CITY OF ALBUQUERQUE

**RE: TR A-1 Plat of TRS A-1 & A-2 Sunport Municipal Addn. (M16D024C)
2200 Sunport Blvd. SE
Grading and Drainage Plan
Engineers Stamp Date 8/26/2022**

FINAL CONSTRUCTION - JANUARY 2023

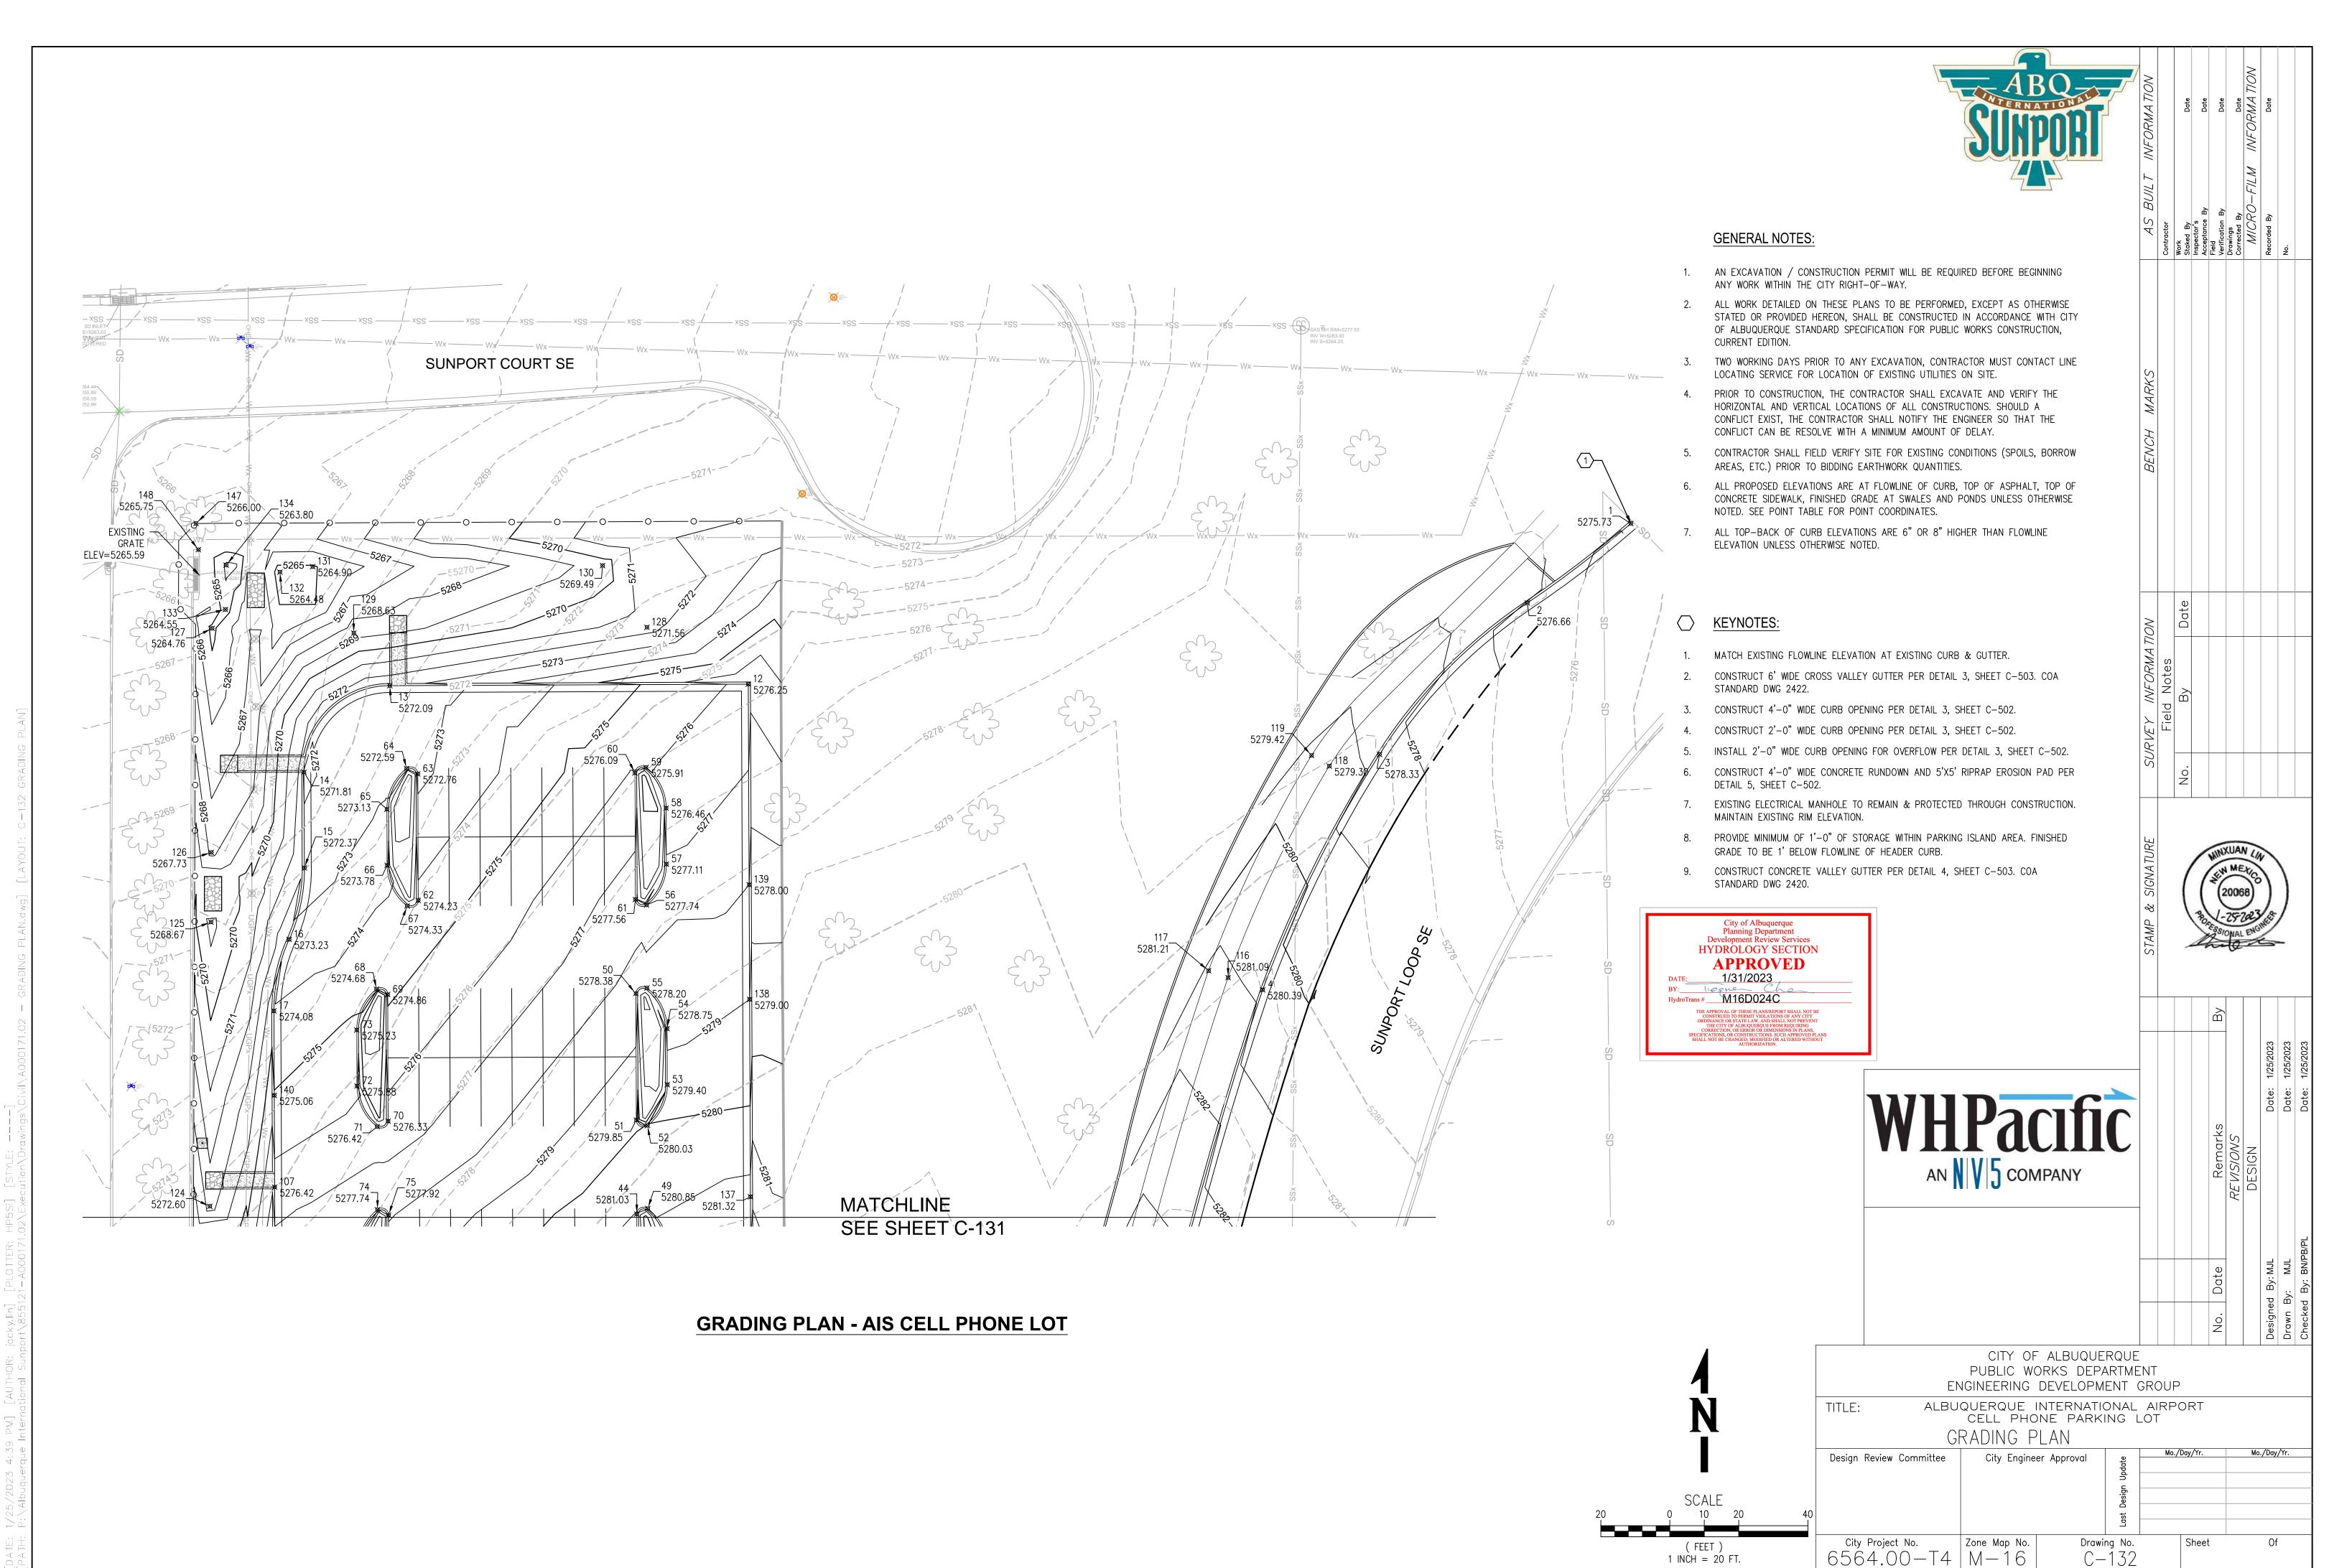
- 2) There is an existing area with buckled sidewalk just north of the start of deceleration lane.
- 3) There is an area were the runoff drains across the entrance. Please include riprap upstream of the low point as well.

- 5) Please provide more information about the existing inlet and provide inlet capacity calculations. Show spot elevations around the inlet to ensure runoff will not drain to the north instead of draining to the inlet. Please include a note that existing inlet to be cleaned (most likely full of sediment).

- 7) Was a Traffic Circulation layout submitted to Transportation for review and approvals?
- 8) Provide Finished Floor elevation for the restroom pad.
